Our Ref: P/10/20/PL

**Town & Country Planning Act 1990 (as amended)
Town and Country Planning (Development Management Procedure) (England) Order 2015
Application for Full Planning Permission**

Development Change of use of existing staff residential accommodation to be used as a separate unit of residential accommodation.
Location The Pagham Club 2 West Front Road Pagham

Existing Floor Plan

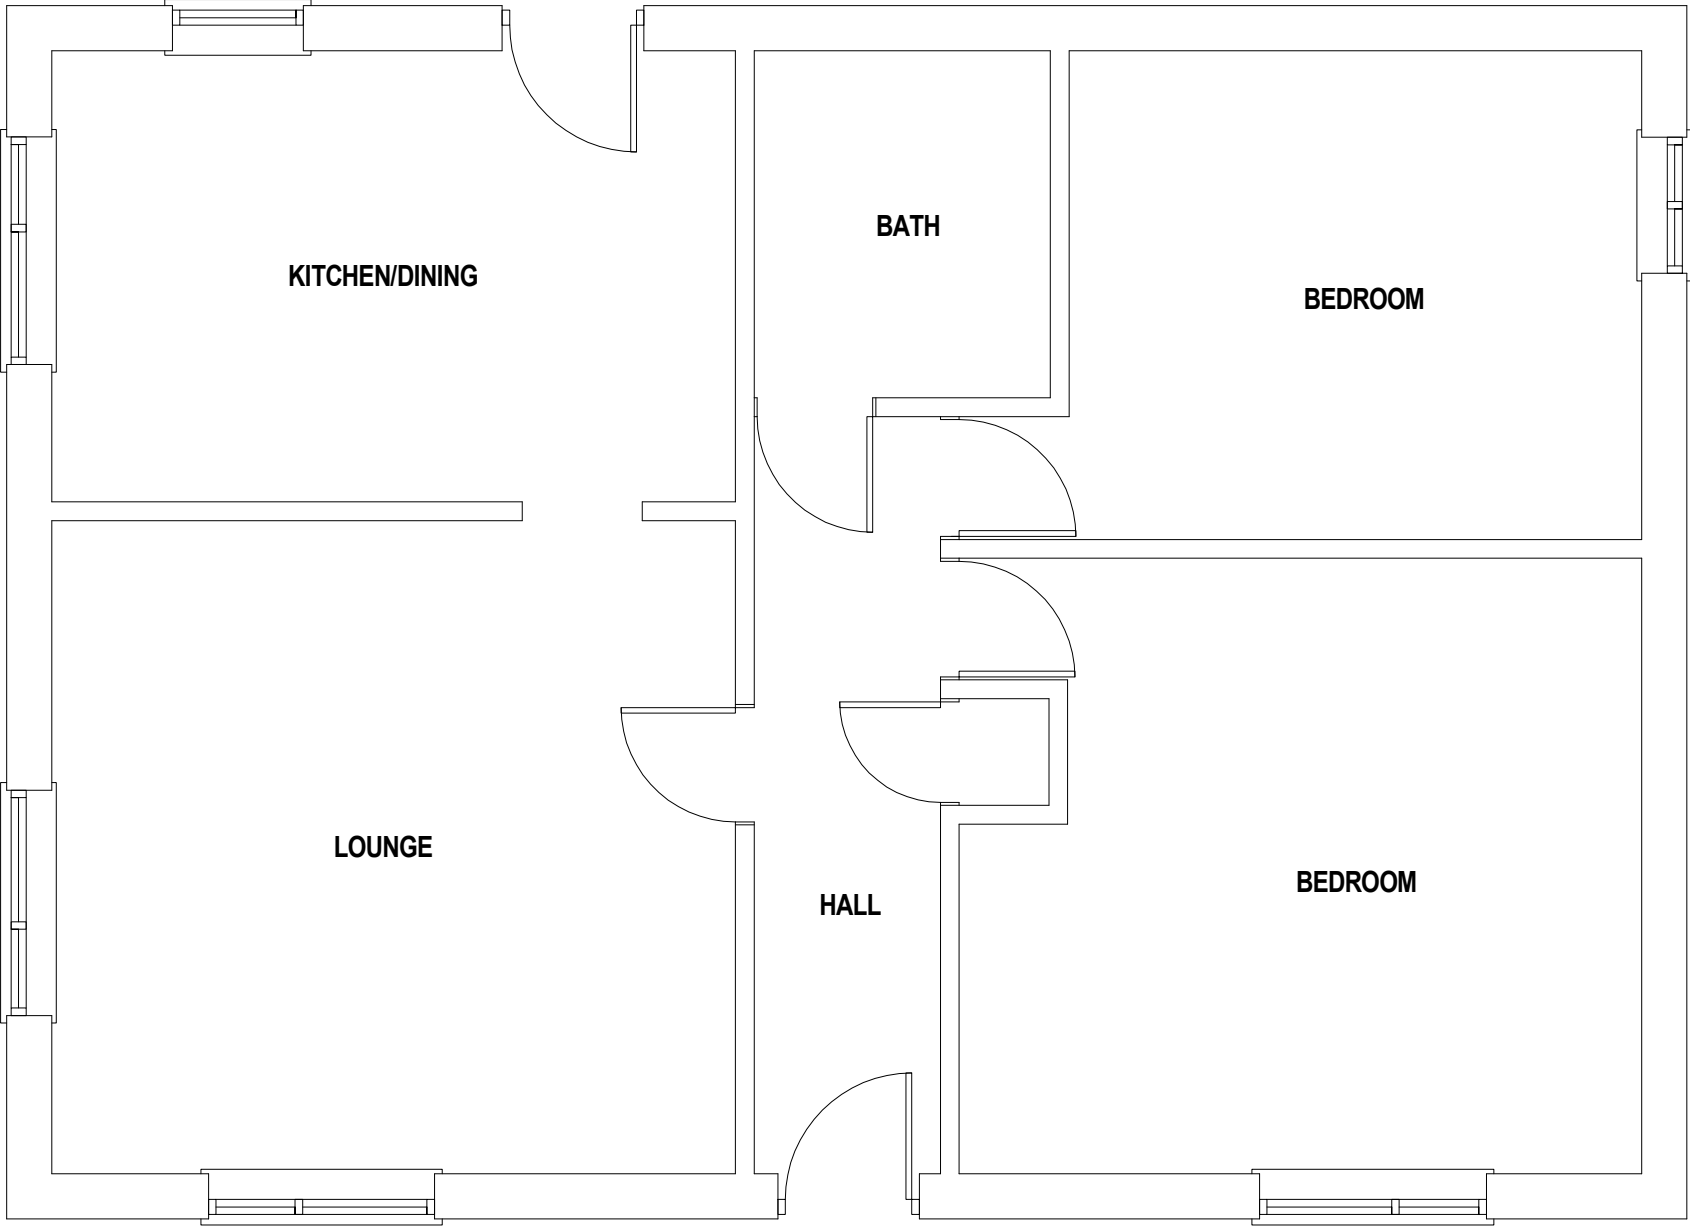
Floor Plans

Please submit 1 electronic or 3 paper copies of clearly labelled floor plans at a scale of 1:50 or 1:100. Further details can be found in the Validation Requirements List.

Location Plan

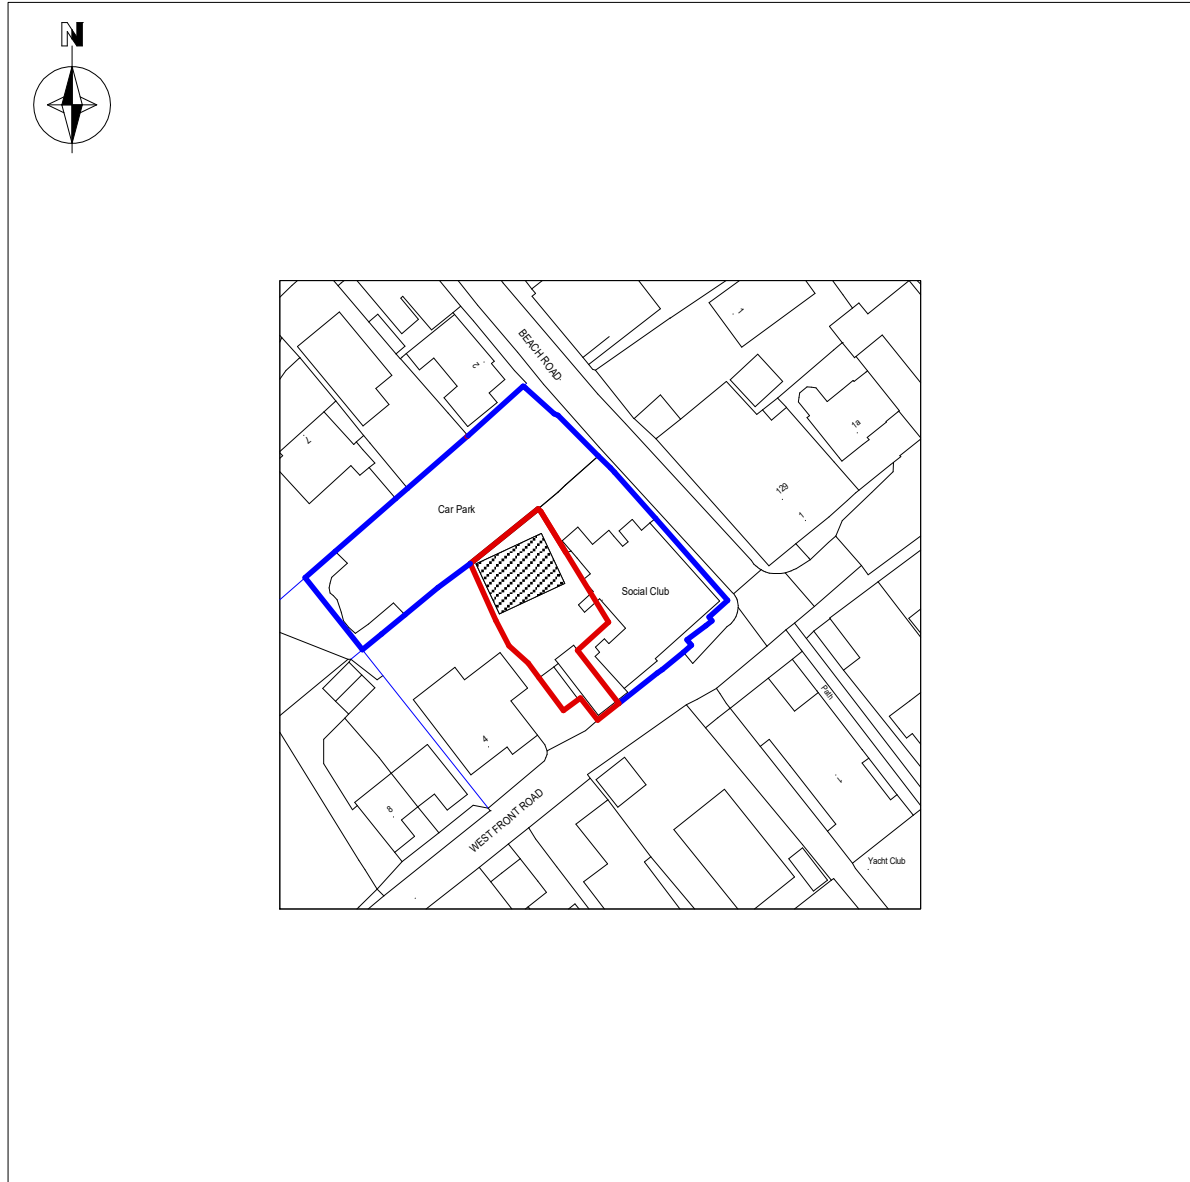
Location Plan Amend

Please only red edge the application site and blue edge any land adjoining the application site that is in the control/owned by the applicant.

**Block Plan REV01**

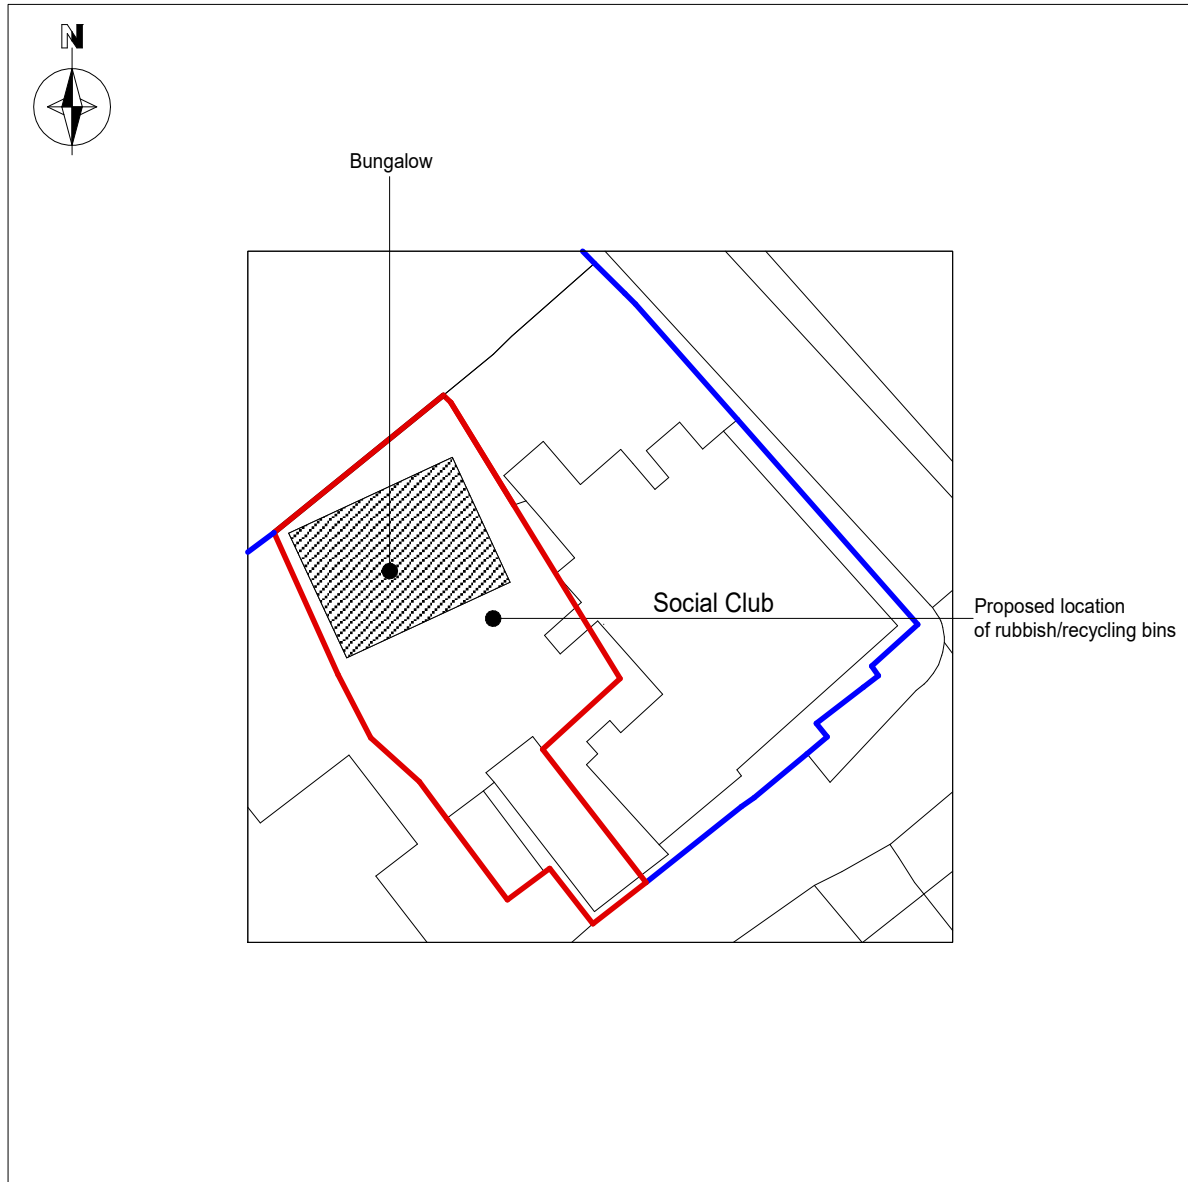
Block Plan Amend

Please only red edge the application site and blue edge any land adjoining the application site that is in the control/owned by the applicant.
